# NATIONAL FLOOD INSURANCE PROGRAM

IN REPLY REFER TO:  
Case No.: 22-06-0212P  
Community: City of Albuquerque, New Mexico  
Community No.: 350002

Identifier:	Oakland Ave Shallow Flooding
Flooding Source:	South La Cueva Arroyo
FIRM Panel Affected:	35001C0137H

## Summary of Additional Data Required to Support a Letter of Map Revision (LOMR)

BASIN EXHIBIT

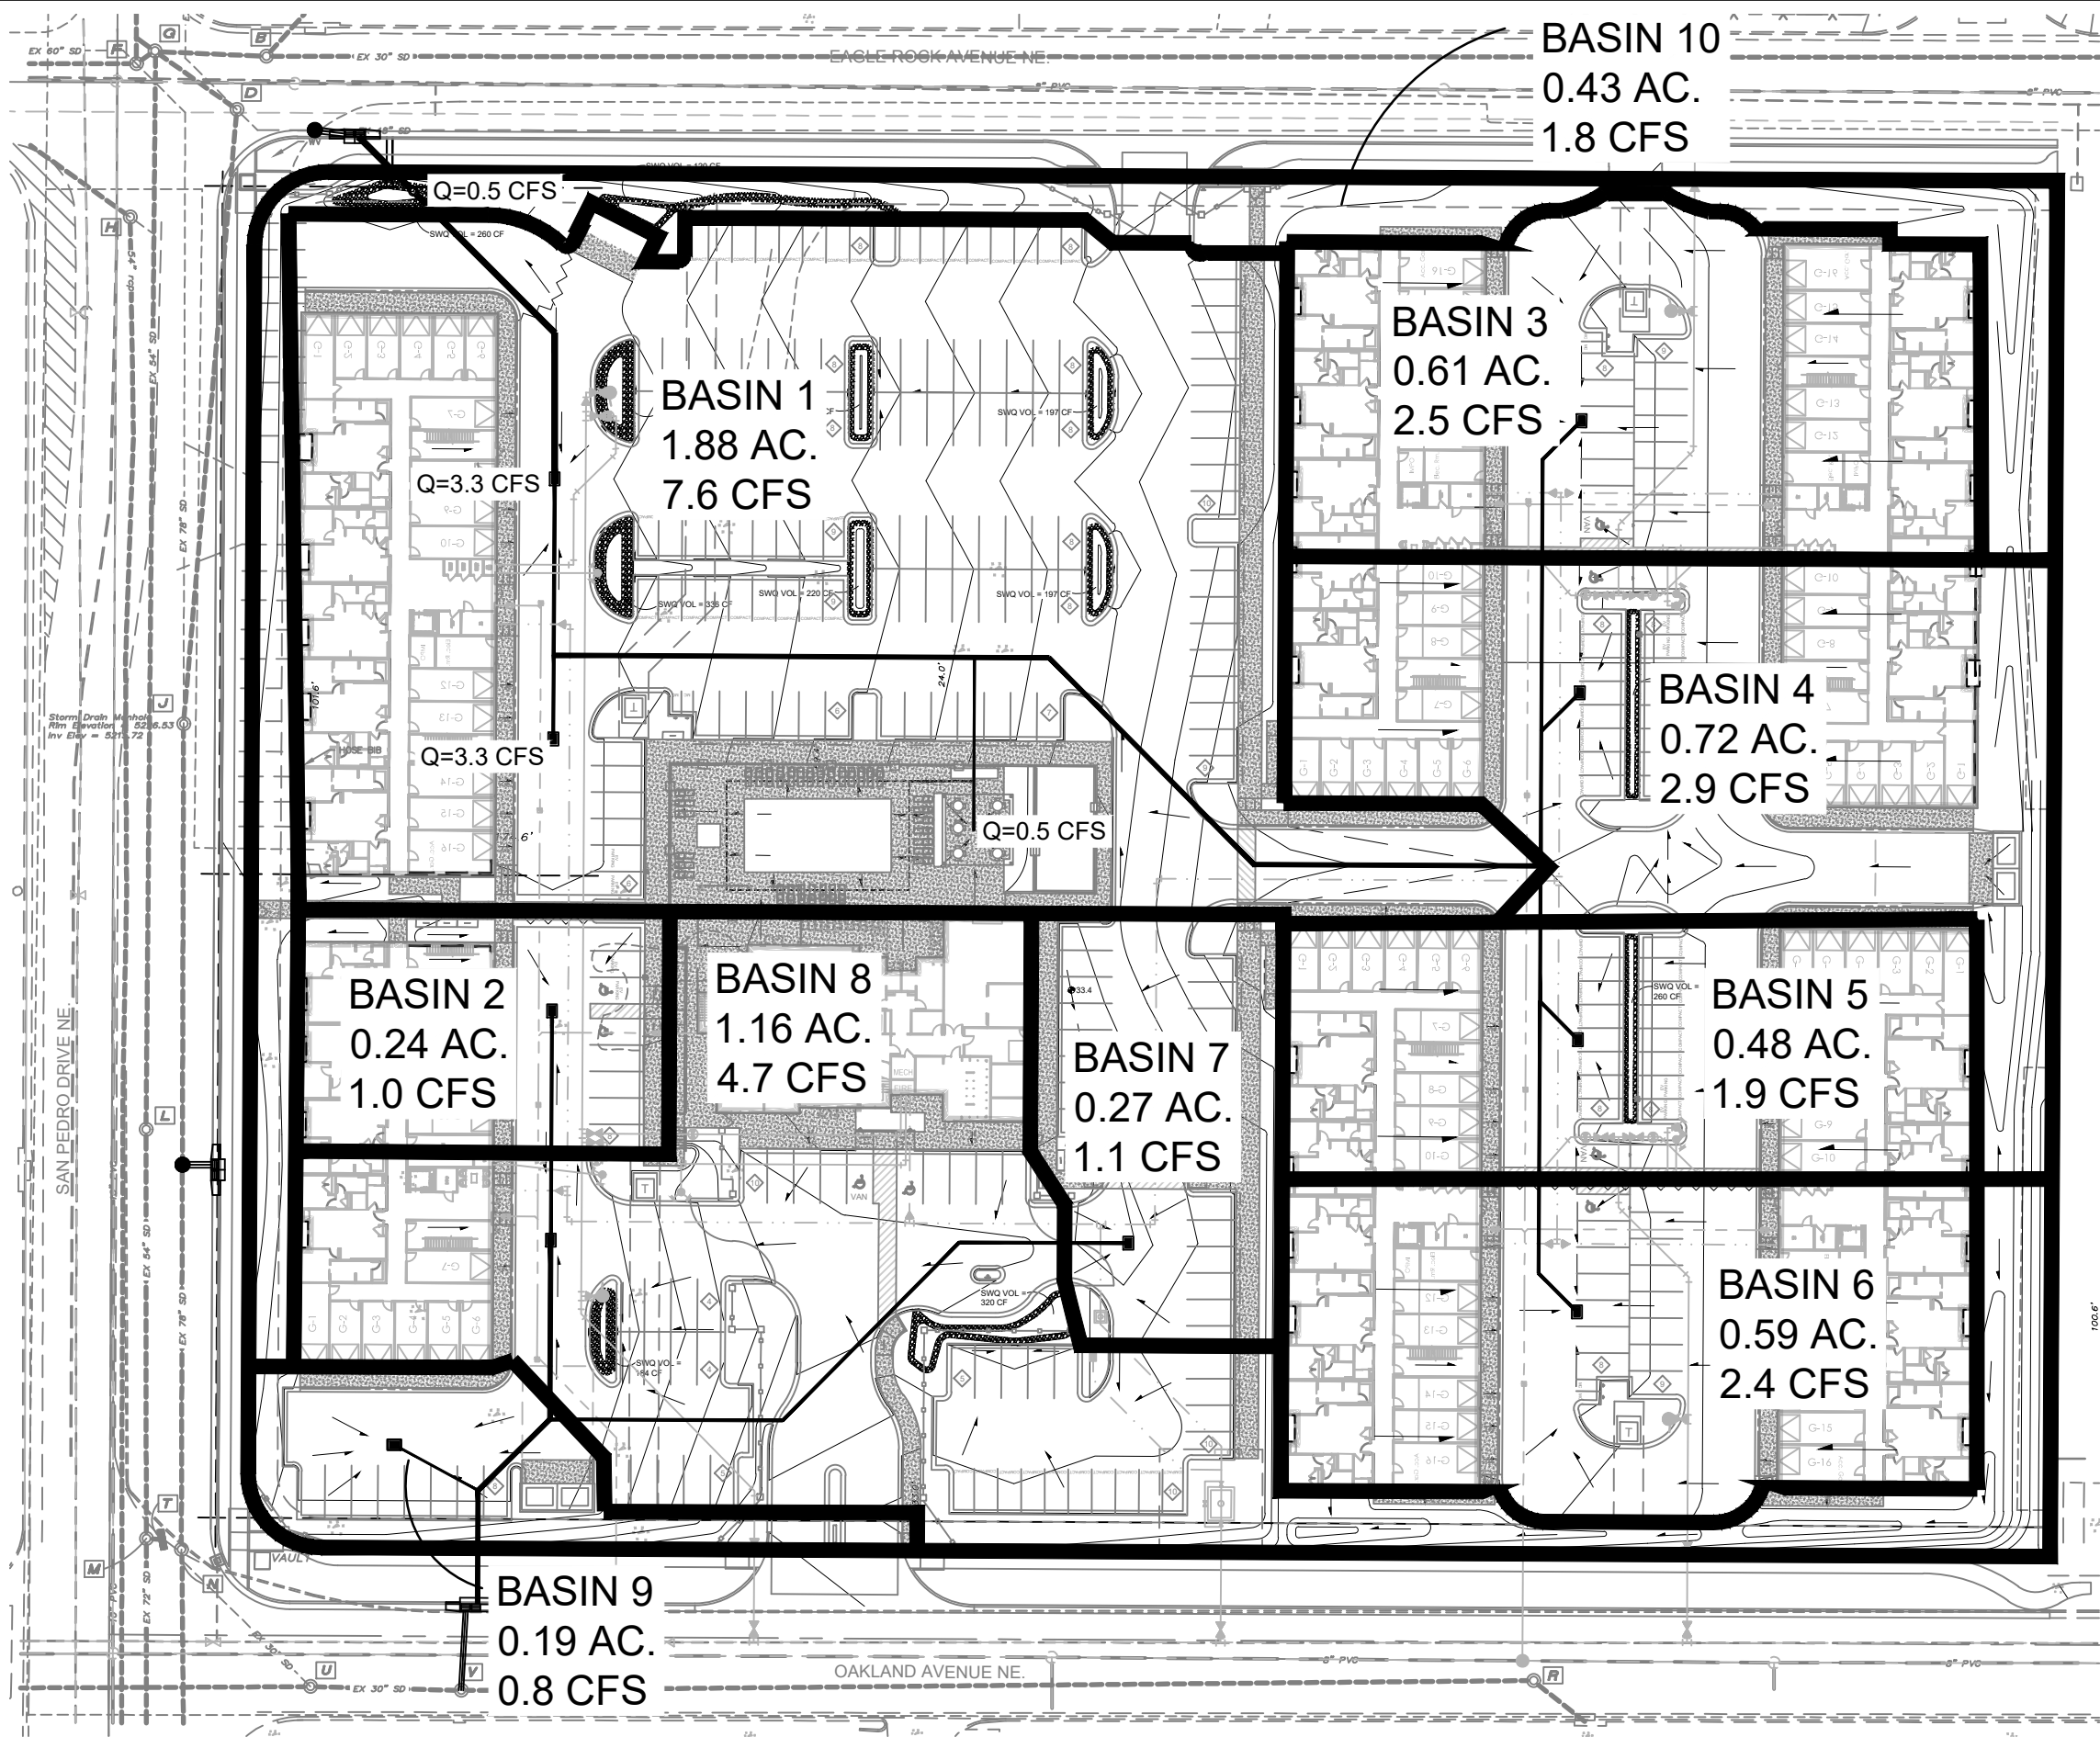
- b. Our review of the drainage area map, entitled "Basin Map," revealed that there are missing contours on the upstream sub basin, missing flow lines showing, and the map was not certified. Please submit a copy of the drainage area map showing the contours used to delineate the sub basins, the flow lines, and certified (signed, sealed, and dated) by a registered Professional Engineer (P.E.). Enough contours should be labeled to be able to verify the delineation.
